Julie Osborne/Peter Tzannes  
Co-Chairmen  
**Centennial Park Residents  
Association ("CPRA")**

15 July 2019

**RE: SYDNEY FOOTBALL STADIUM ("SFS") REDEVELOPMENT  
STATE SIGNIFICANT DEVELOPMENT APPLICATION – Stage 2 Design, Construction and  
Operation - Environmental Impact Statement ("EIS")**

Figure 42: Accessibility of Precinct Context

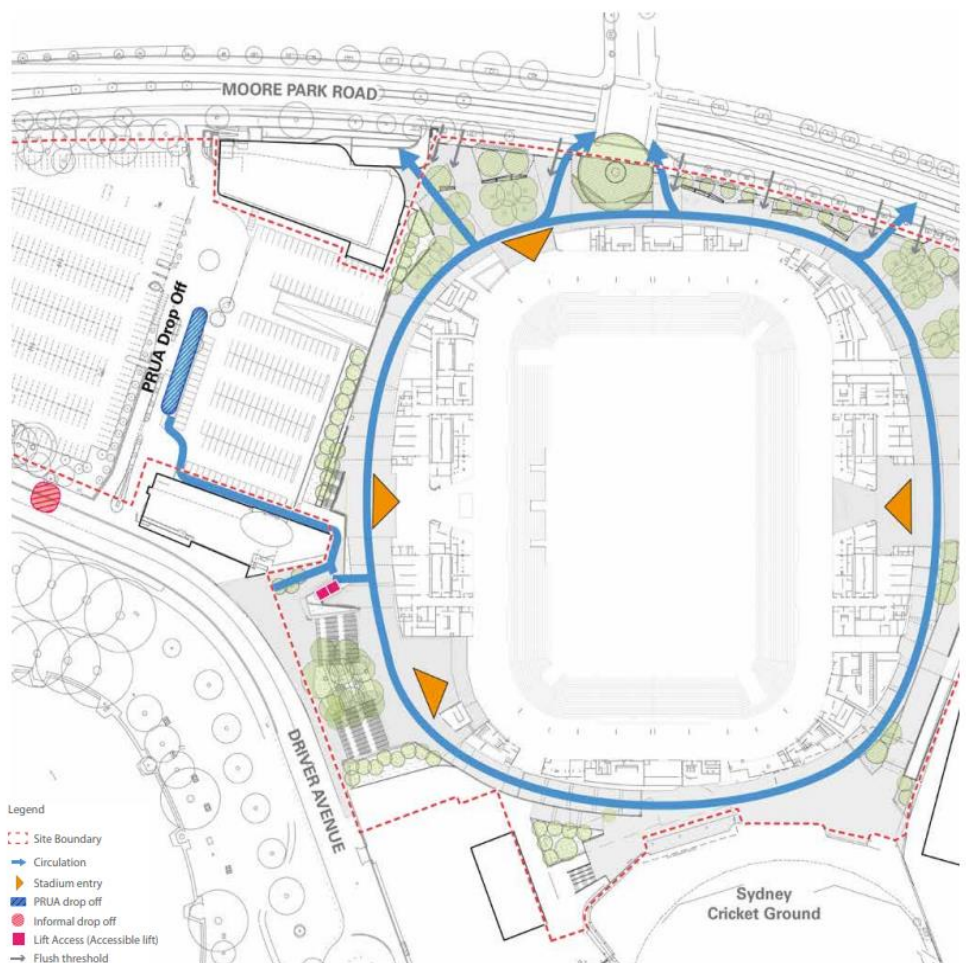
As the stadium has been designed to provide on grade access at Moore Park Road, the Driver Avenue entrance is by definition significantly lower due to its topography. To provide access, the design incorporates a bank of stairs that are approximately 6 metres from street level. Given it has been acknowledged that the vast majority of patrons will utilise this entrance, significant safety concerns arise. These concerns arise when large crowds of people enter and exit the stadium in circumstances where they are trying to do so in emergency situations or where some are intoxicated or pushing to exit speedily. All of these instances increase the possibility of crowd crush and falls. This has the potential to be very dangerous and to cause injury.

In addition, such a large number of stairs raise issues of accessibility for the disabled, for families and the aged. The provision of just 2 elevators is markedly insufficient for the expected number of attendees.
